From: SIMON ANCELL [REDACTED]
Sent: 21 September 2012 09:25
To: Charlotte Burrows
Cc: hda projects
Subject: Re: Application AL10312
Attachments: 1124 P 01 Rev A Block Plan +.pdf

PP-02201003 Resubmission 2 New Cottages Shripney Road

Block Plan I : 500

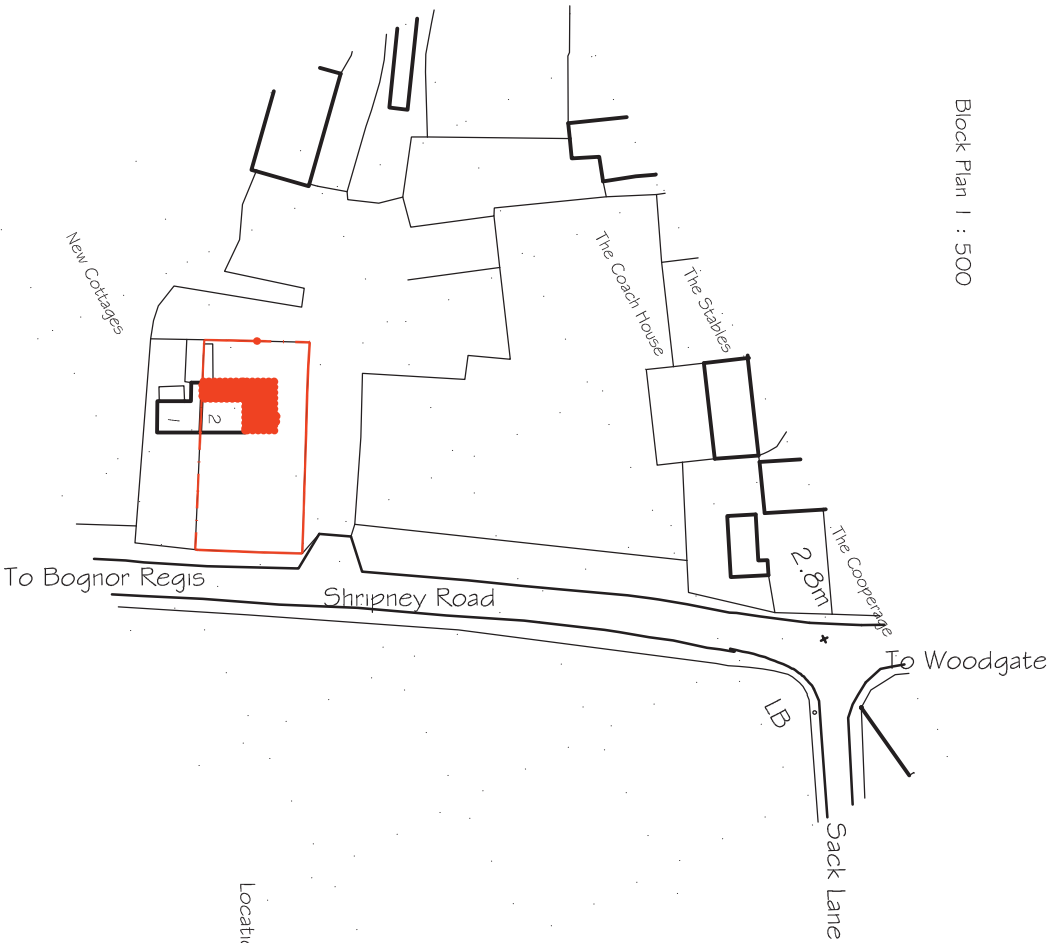
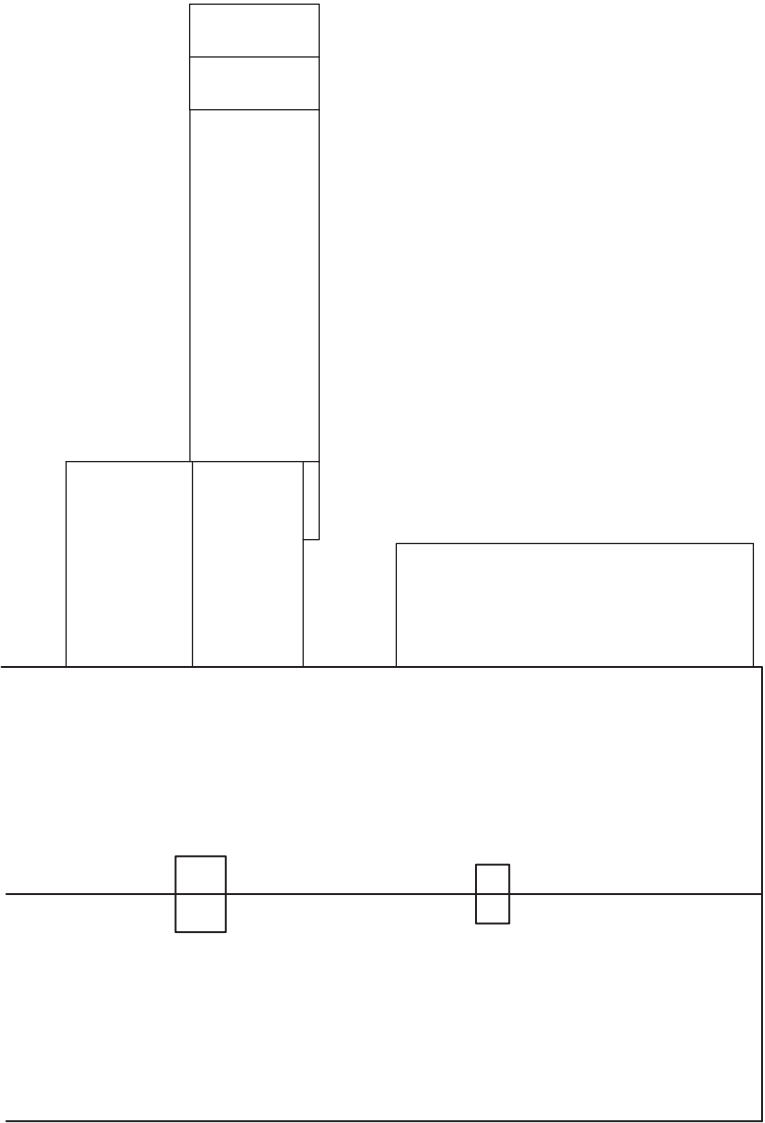
We have received an email from your agent notifying us that as he is on holiday we should notify you with any queries, unfortunately there is one outstanding item. We require one named road to be included on the submitted Block plan. If you wanted to make the amendment I could send you a copy of the plan, however I have also sent a copy to your agent.

Should show junction of Sack Lane and Lidsey Road

I have added the road name to the block plan as requested, please confirm that this is the information you were looking for.
